Our Case Number: ABP-311528-21

**An
Bord
Pleanála**

Date: 11 February 2022

Re: Construction of a 2 storey 220kV GIS substation known as 'Mooretown', 4 underground transmission cables and all associated and ancillary site development and construction works. Lands adjacent to Huntstown Power Station, North Road, Finglas, Dublin 11

MOORETOWN 220 KV SUBSTATION
PROPOSED SUBSTATION LOCATION

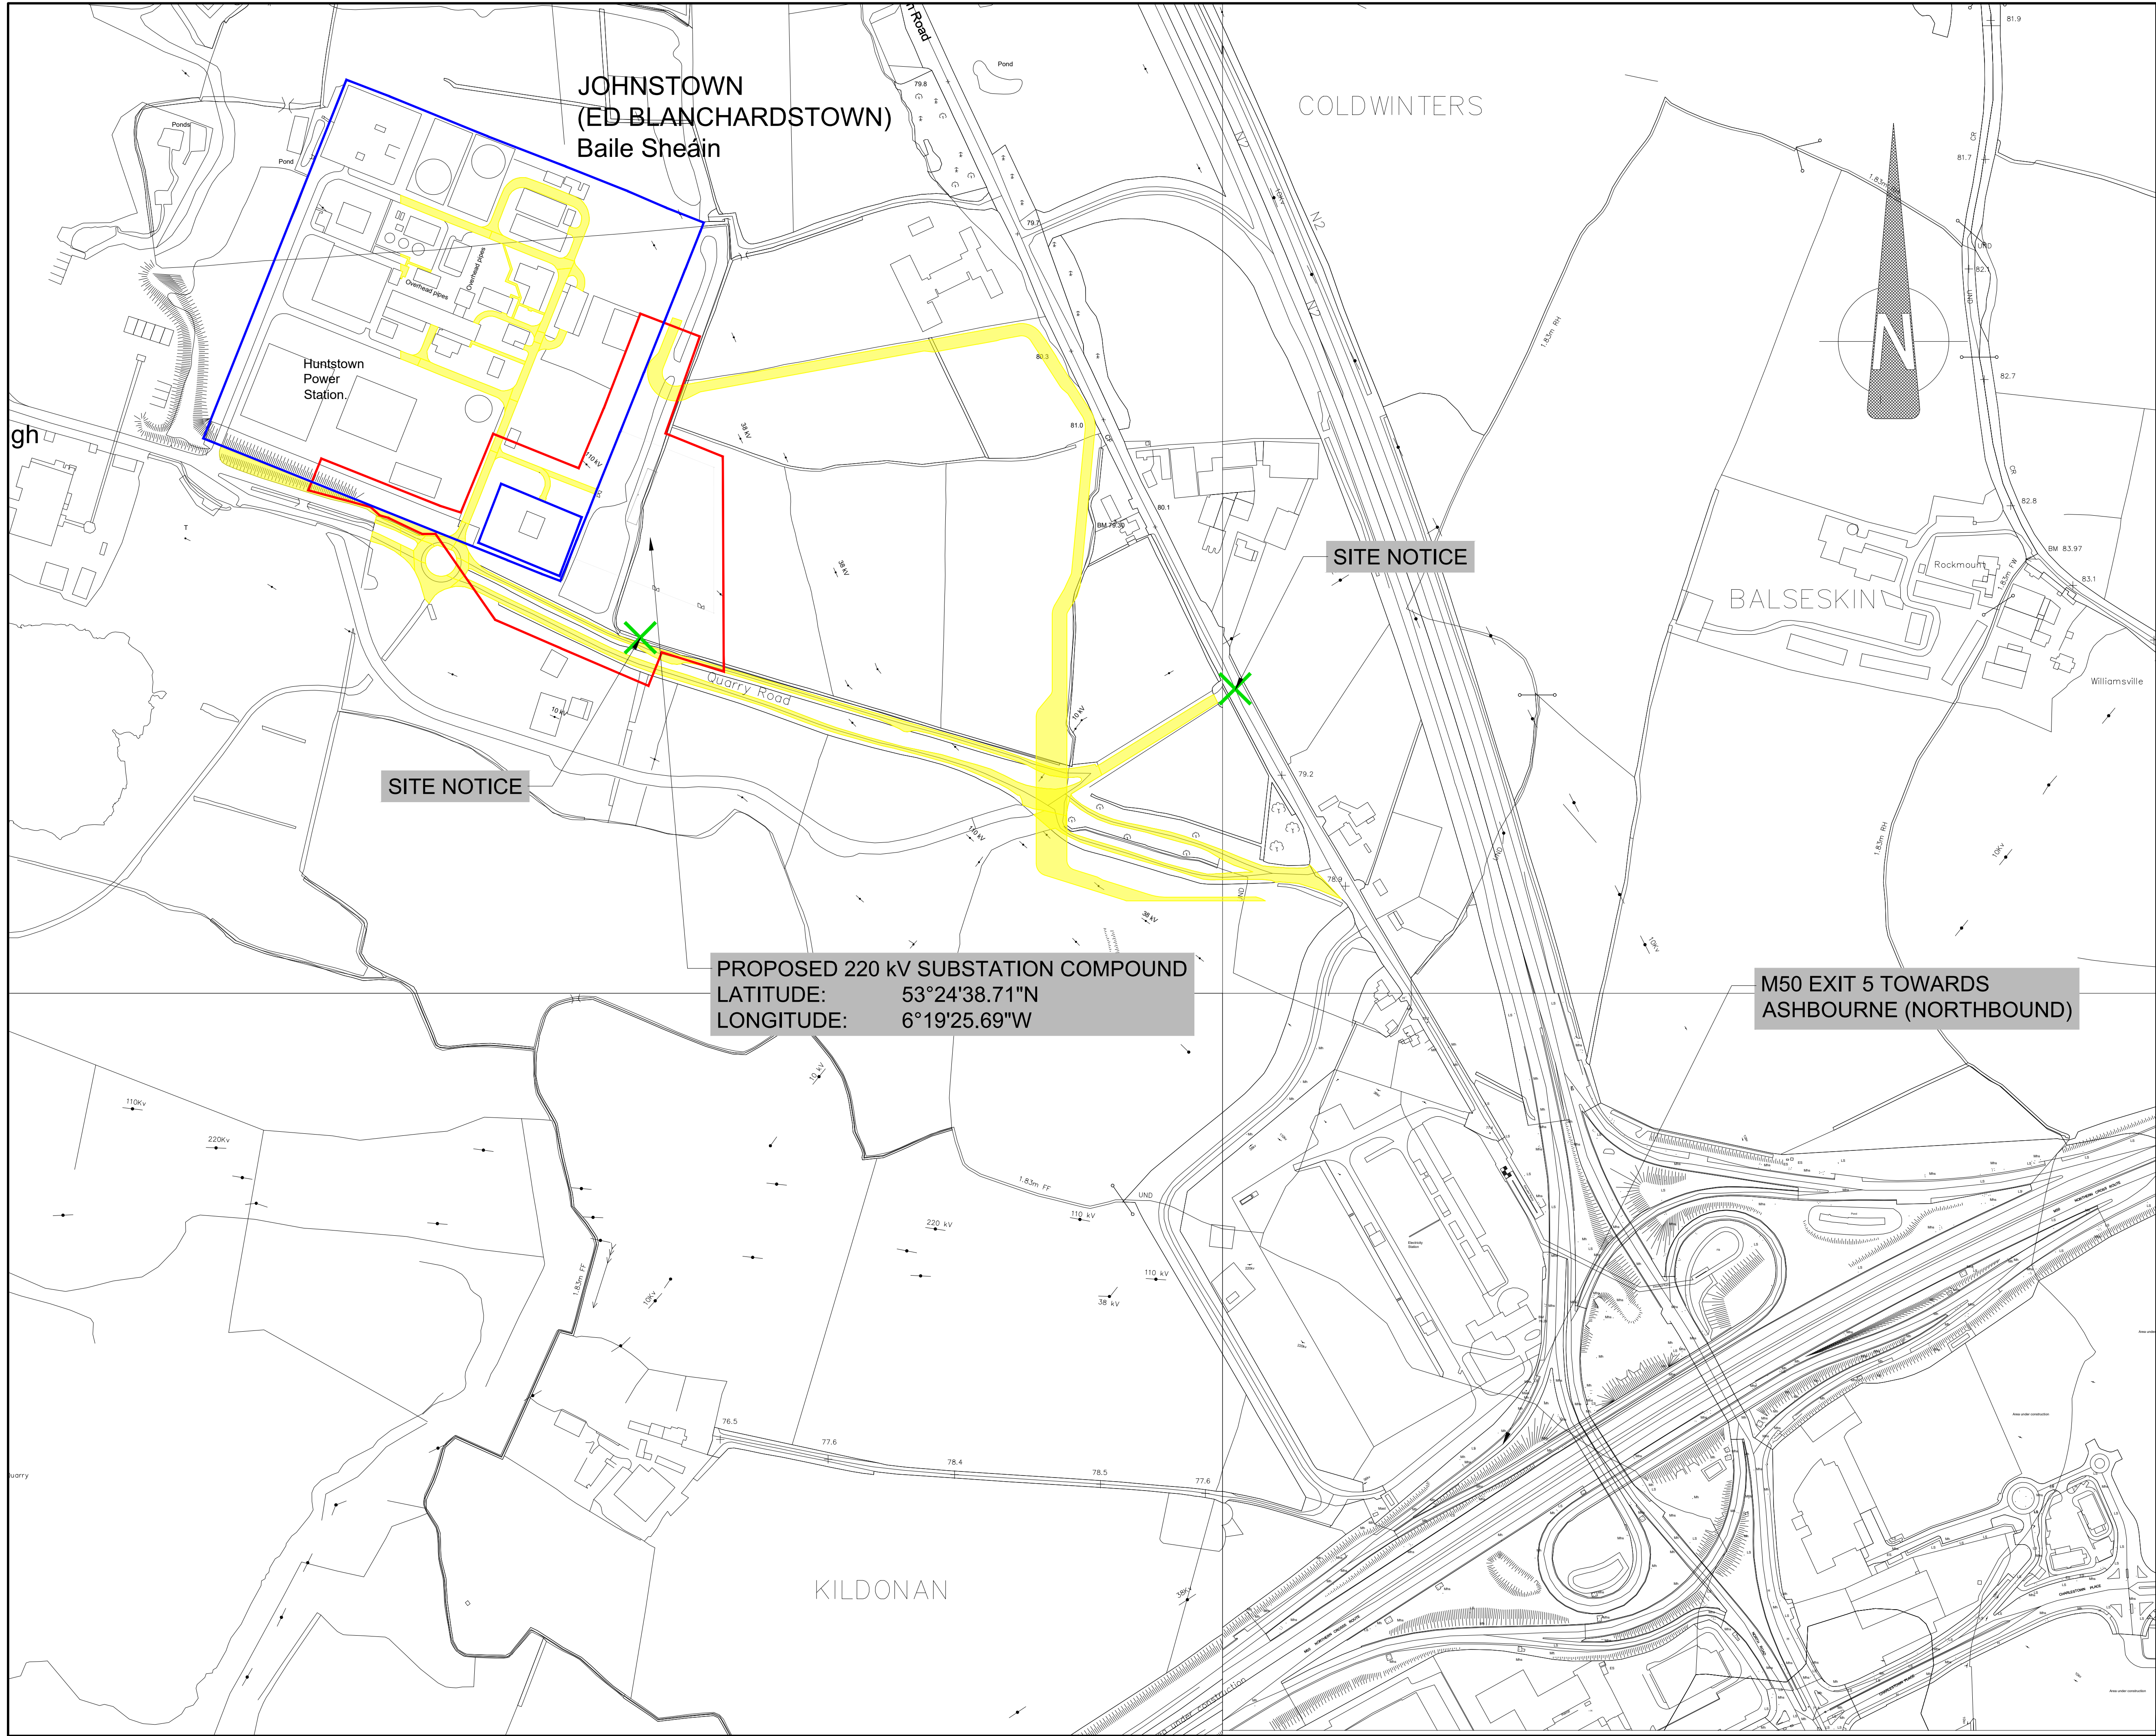
The application documentation shows connections between the planned substation and data centre. Of particular relevance to the substation application is its reliance on the data centre site for the purposes of construction access and for surface water drainage.

You are invited to consider an amendment to the site boundary so that the defined site area encompasses a complete development which would be capable of implementation independent of the planned data centre.
